OXFORDSHIRE COUNTY COUNCIL'S RESPONSE TO CONSULTATION ON THE FOLLOWING DEVELOPMENT PROPOSAL

Application no: 23/00501/REM

Proposal: Reserved matters application & condition discharge of Part B of 19/00128/HYBRID - Part B: Outline planning application - the development of up to 2 no. commercial buildings having a maximum floorspace of 16,890m² and having a flexible use [to enable changes in accordance with Part 6 Class V of the Town and Country Planning (General Permitted Development) Order 2015 (as amended)] within Class B2 or B8 of the Town and Country Planning (Use Classes) Order 1987 as amended, and ancillary Class B1 offices, with all other matters reserved for future approval (19/00128/HYBRID)

Location: Unit 2, Kalabergo Close, Banbury, OX17 2FJ

Figure 2. Proposed Site Plan

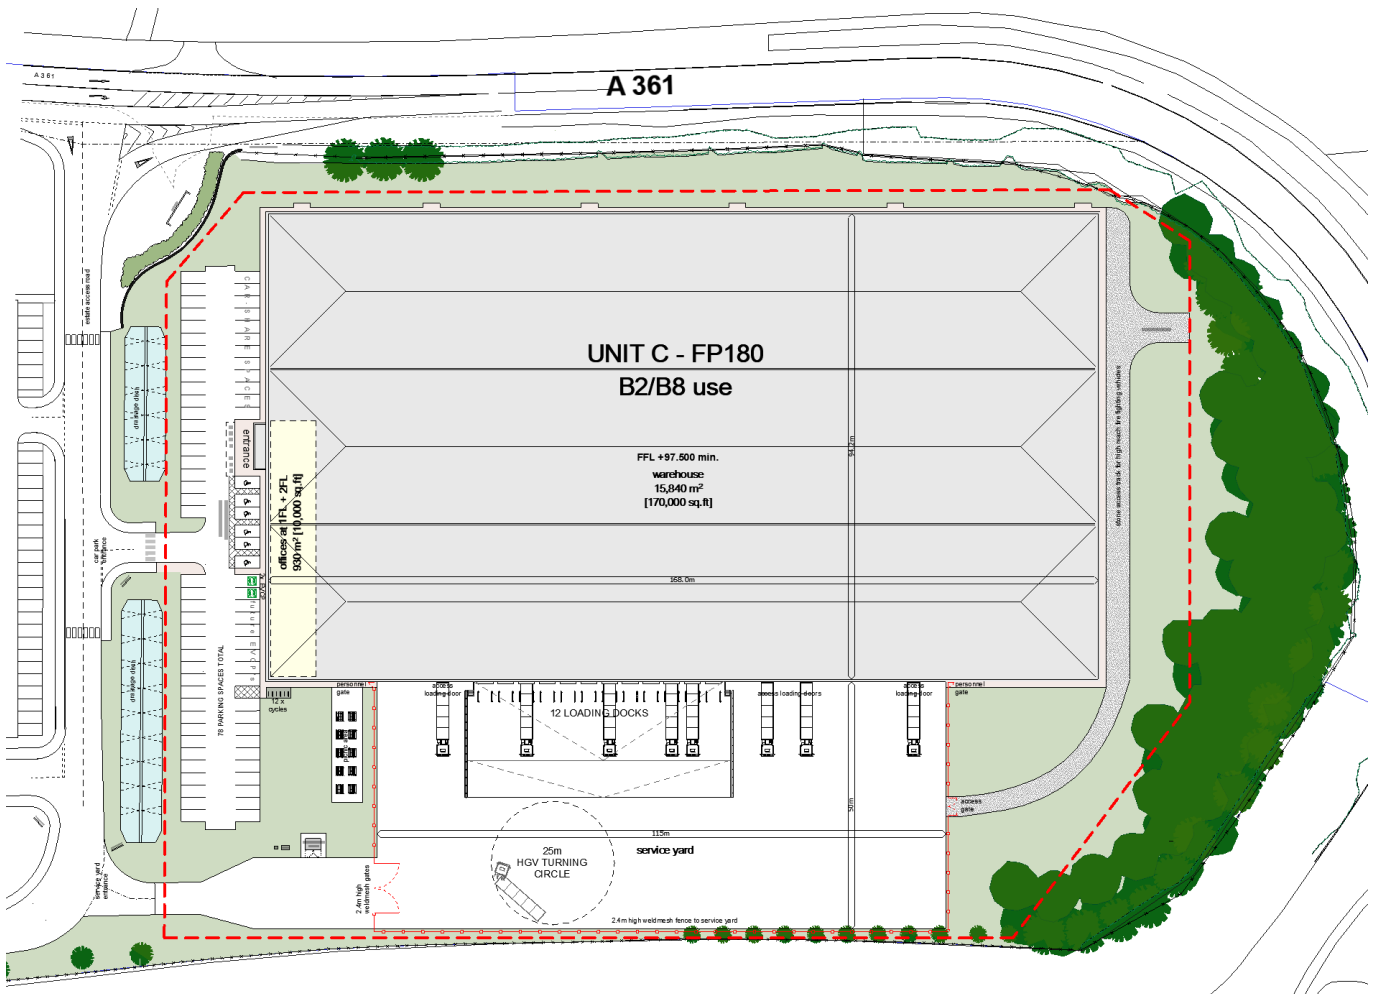
Since that date, a revised Site Plan (drg. no. 902 rev. F) has been submitted.

The previous response contained an objection due to the lack of Electric Vehicle (EV) charging points. The revised site plan now shows 10 spaces with EV charging and 10 allocated for facilities in the future. However, the adopted strategy is clear that a minimum of 25% of spaces must have charging points so this must be from first occupation, not at some point in the future which may never be implemented.

The overall number of spaces has not been justified, despite the previous objection for that reason. There is still a shortfall when compared to the other two existing units.

Given that 79 spaces are proposed, this can be considered as just acceptable. Travel Plan measures should be used to encourage car-sharing (using the 12 spaces allocated for that purpose) and cycling, to ease the overall demand for car parking spaces. I remain concerned, however, that any overspill parking will lead to obstruction of the access road which provides a route for a bus service as well as HGV access to all three units. Therefore, I request a condition for car parking management, so that levels of parking demand can be monitored and to set out how overflow parking can be managed.

The total number of cycle storage spaces has been increased to 96, in line with comments in the previous response, so this reason for objection may be removed. It is hoped that suitable changing facilities are provided within the building so that cycling may be promoted.
